**From:** Mark Peacock  
**Sent:** 04 January 2017 14:04  
**To:** Andrew Windscheffel  
**Subject:** S6/2014/2292/FP - Cuffley Pipeline

Please can you update the file with the attached amended Site Location Plan received today. This supersedes drawing 1967-D1100-rev00.

1967-D1100-rev00
Scale: 1:5000 @ A1
Scale: 1:10000 @ A3
Date: 21 February 14

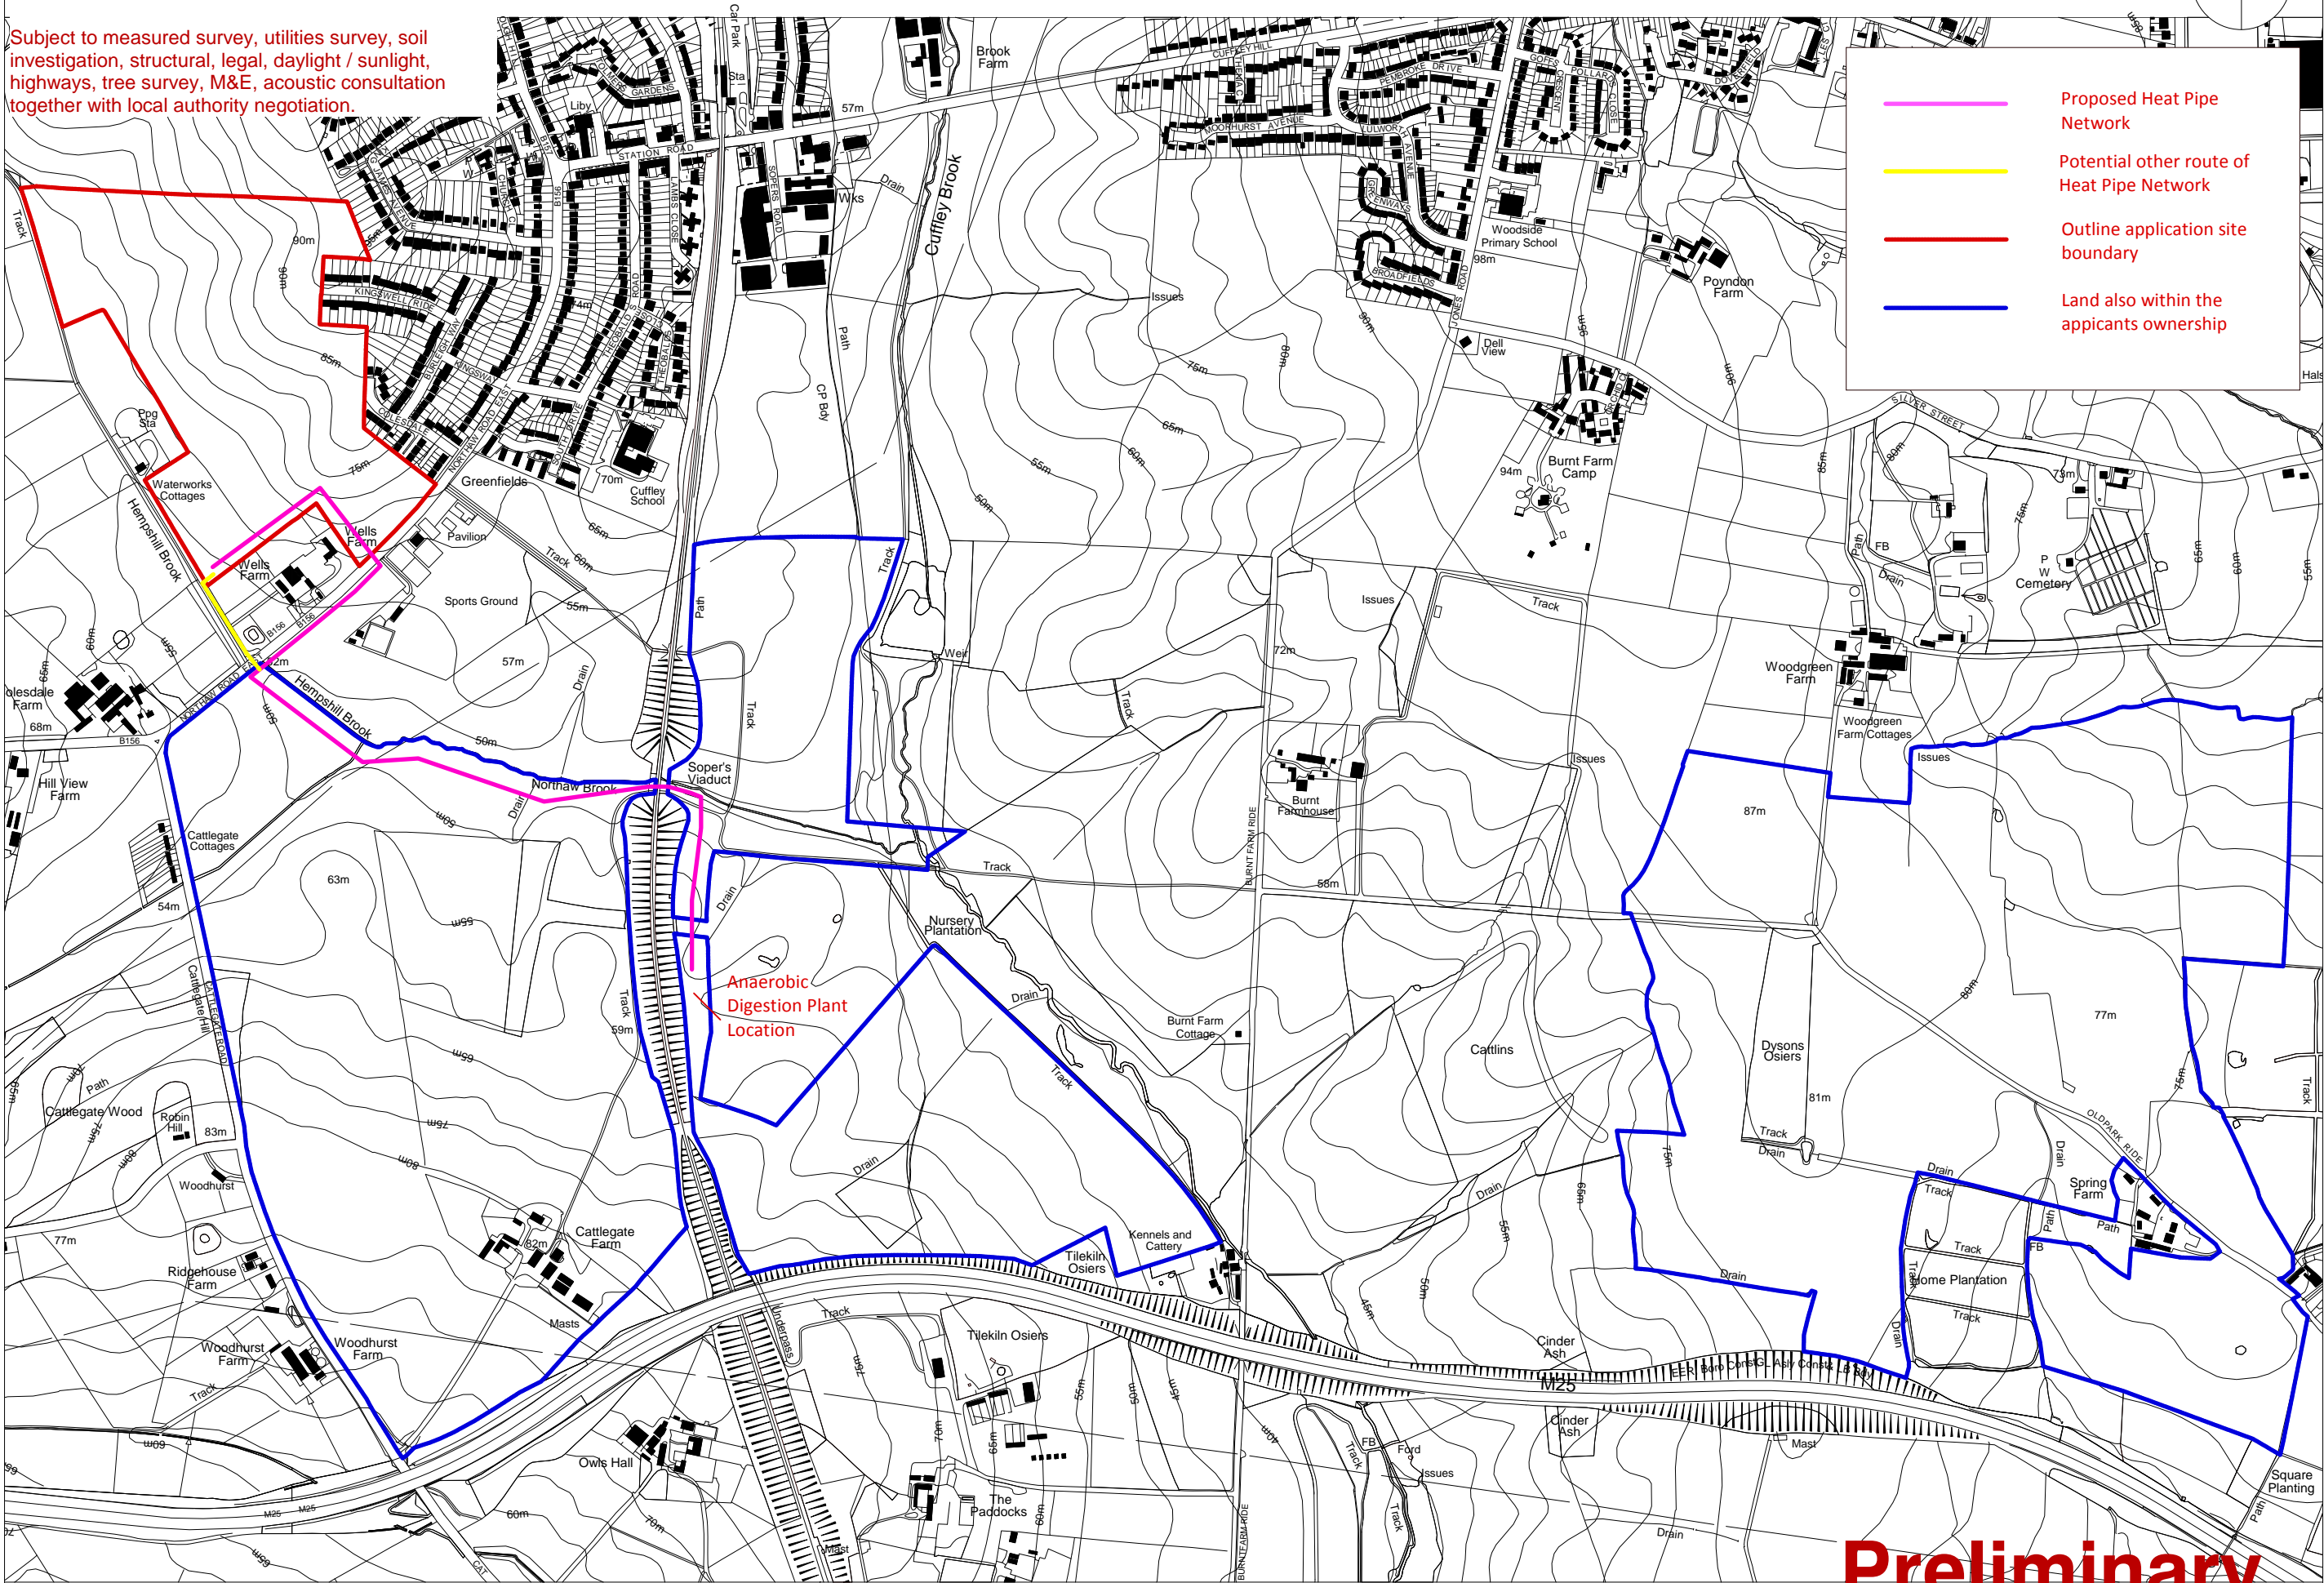
The reason for superseding drawing 1967-D1100-rev00 is that it showed a route for the pipeline which was inconsistent with the route shown within the Arboricultural Impact Assessment and Tree Reference Plan.
